Your Ref: OWPC15438
Our Ref: FG/135/17/PL 18-08-2017
Please ask for:
Mrs A Gardner

Erection of 1 no. 2 bed dwelling
South Point Beehive Lane Ferring

Thank you for your internet representation made on 2nd September 2017 which has been recorded as '**an objection**' with the comments as follows:

Proposed Block Site Plan - 1:200 @ A1

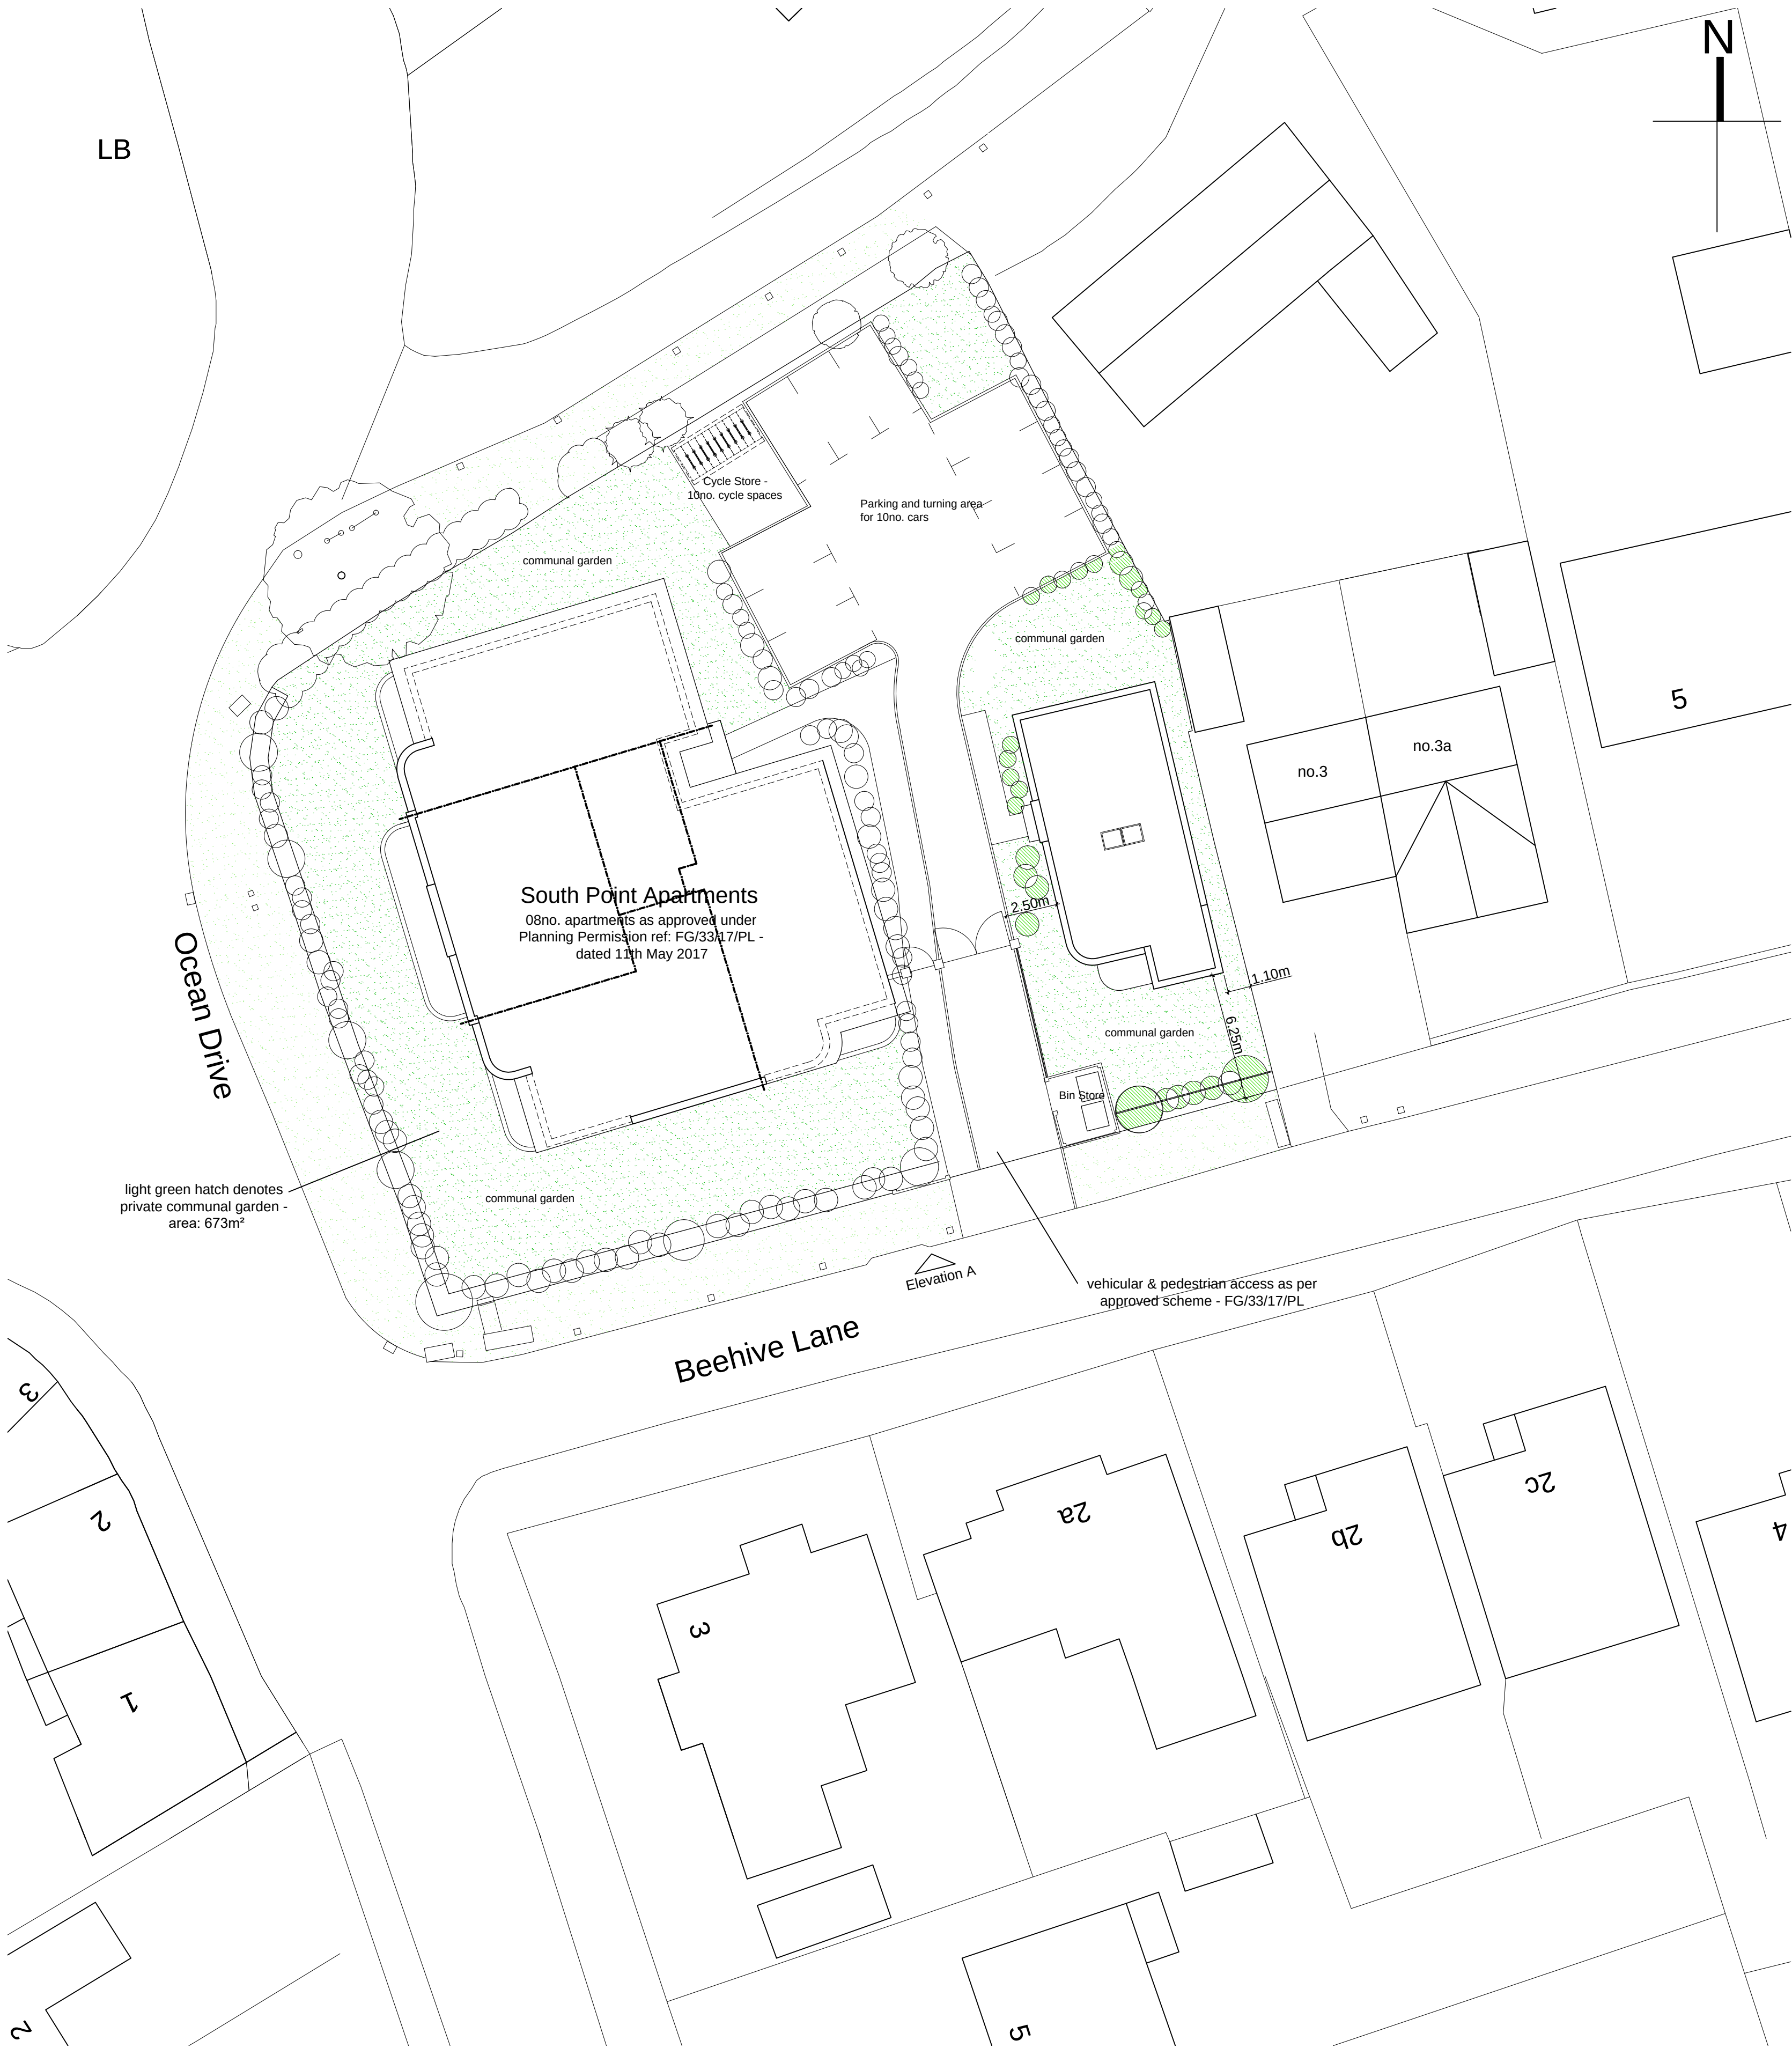
The original plan for 4 bungalows was altered for 10 flats. This was refused and 8 allowed with strict guidelines. This new application trying to squeeze extra flats in will be on the communal garden area & leave less gap between properties.
